6870  
CS  
**United Utilities Water PLC**  
**Developer Services & Planning**  
Thirlmere House  
Lingley Mere Business Park  
Lingley Green Avenue  
Great Sankey  
Warrington WA5 3LP

**Your ref:** 3/2012/0567  
**Our ref:** DC/12/2878  
**Date:** 30-JUL-12

**Location: Dove Cottage Whalley Road Sabden Lancashire BB7 9DT**  
**Proposal: Erection of a detached Chalet**

PROPOSED GUEST ACCOMODATION
DOVE COTTAGE - WHALLEY ROAD - SALDEN

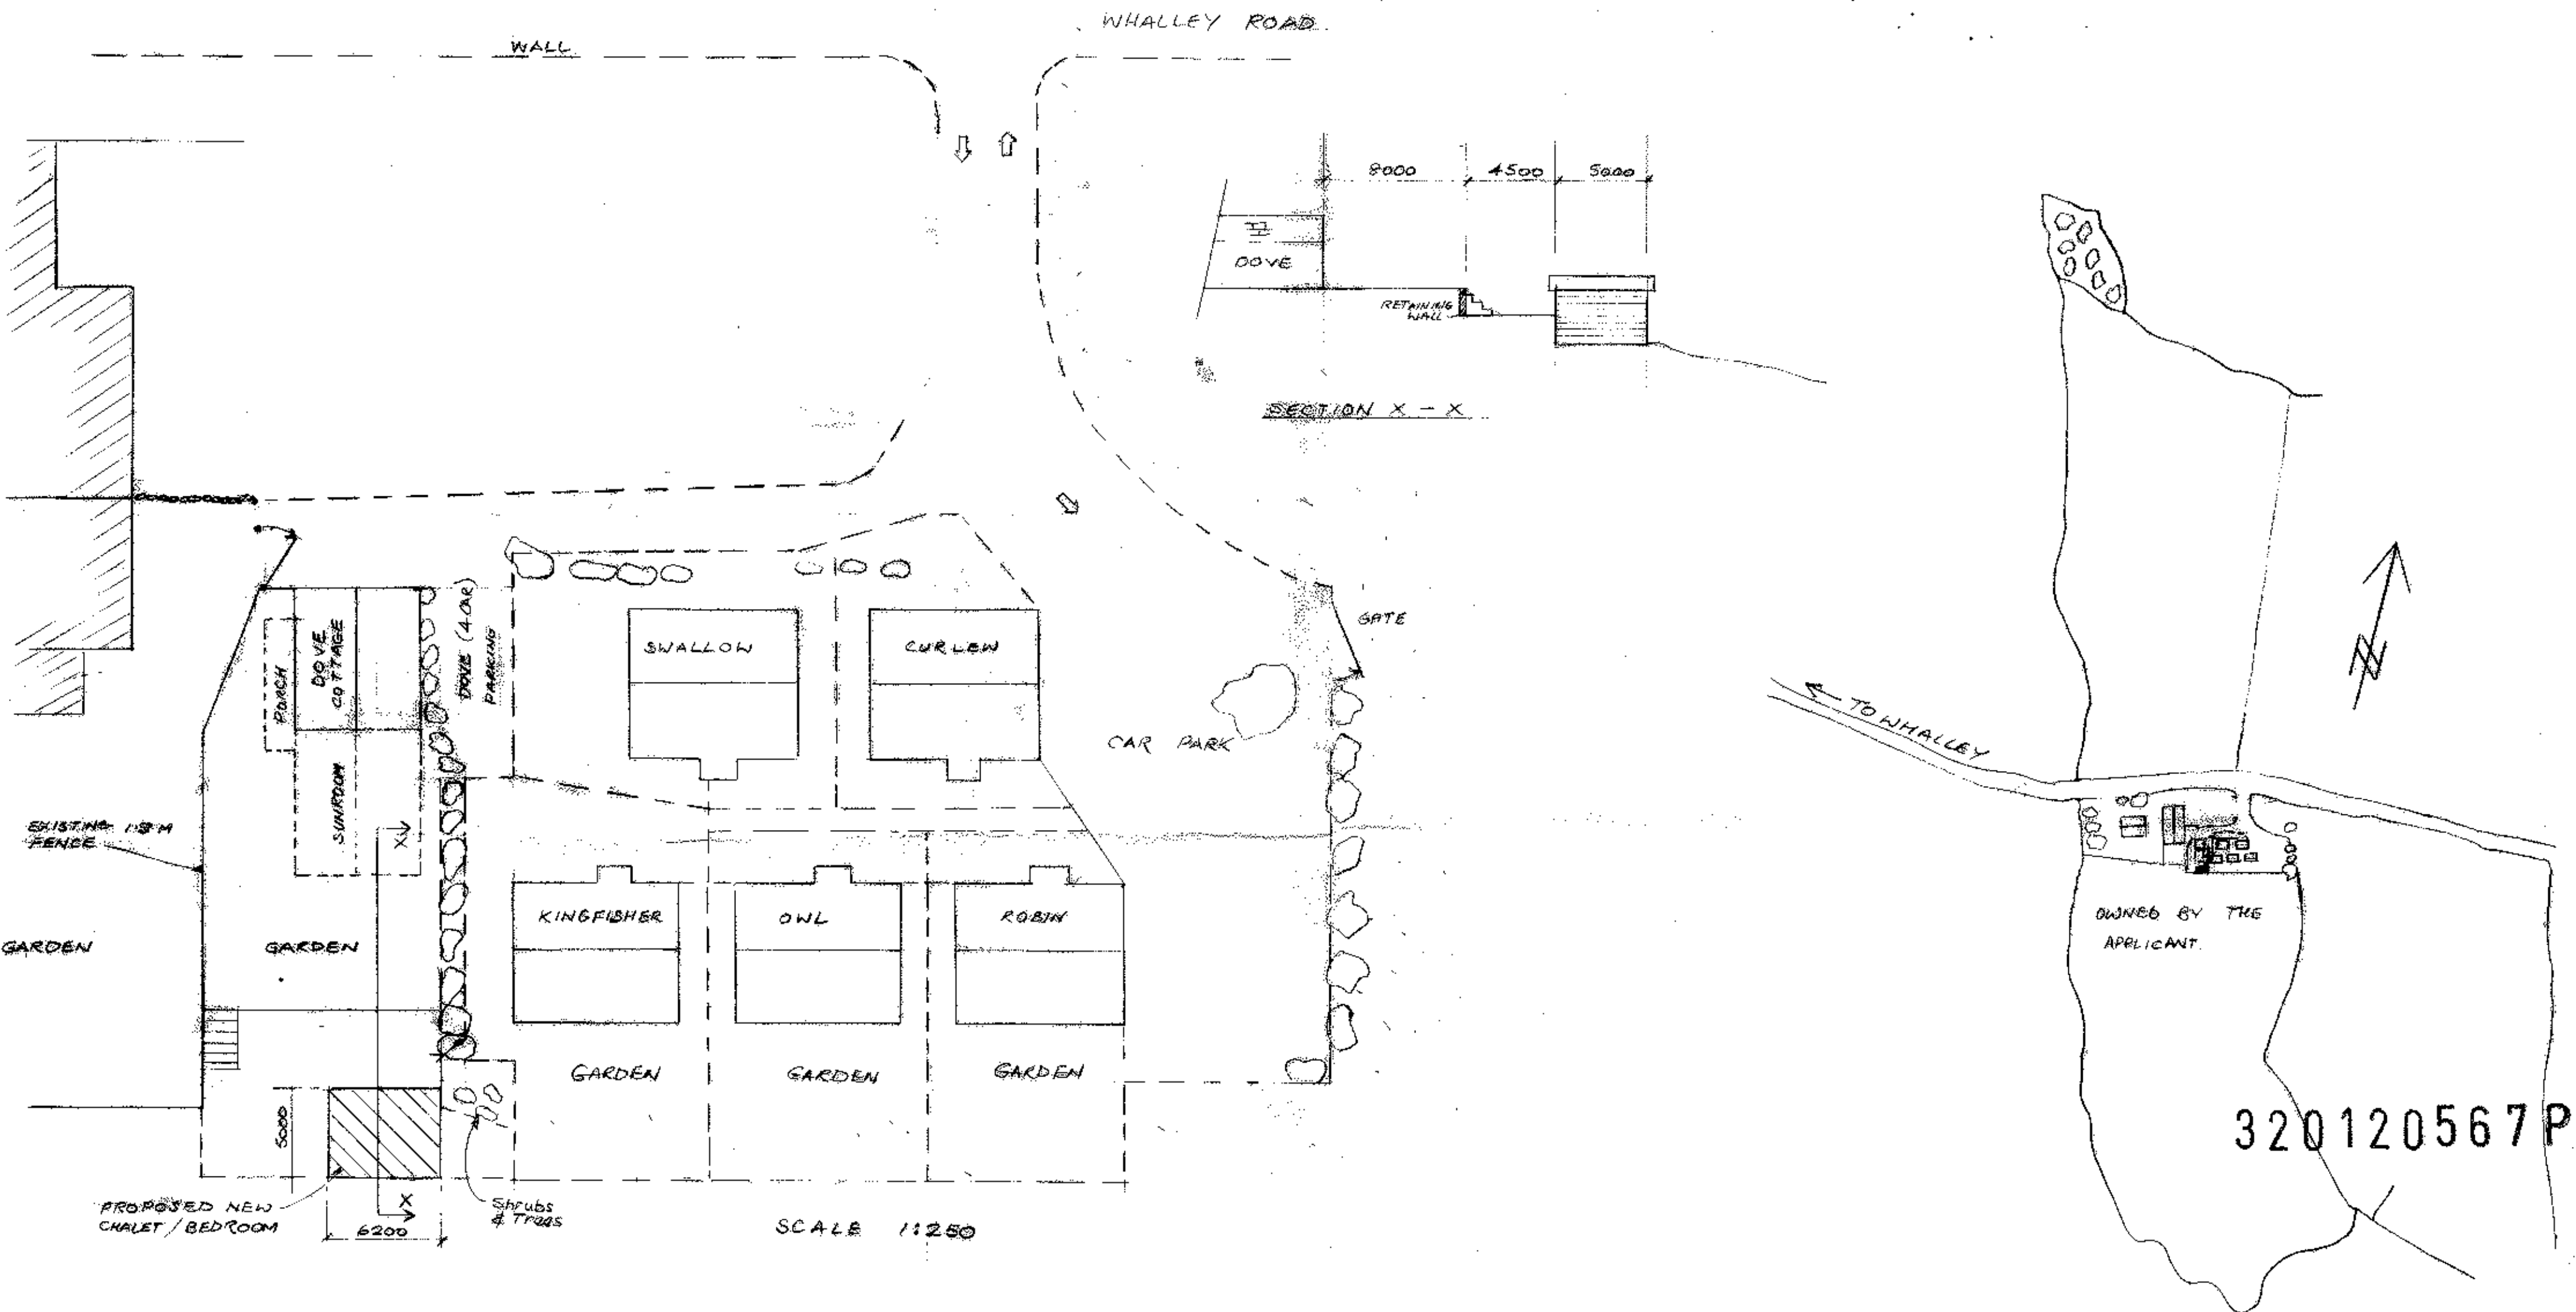
- A water main crosses the site. As we need access for operating and maintaining it, we will not permit development in close proximity to the main.

A modification of the site layout, or diversion of the main at the applicant's expense, will be necessary.
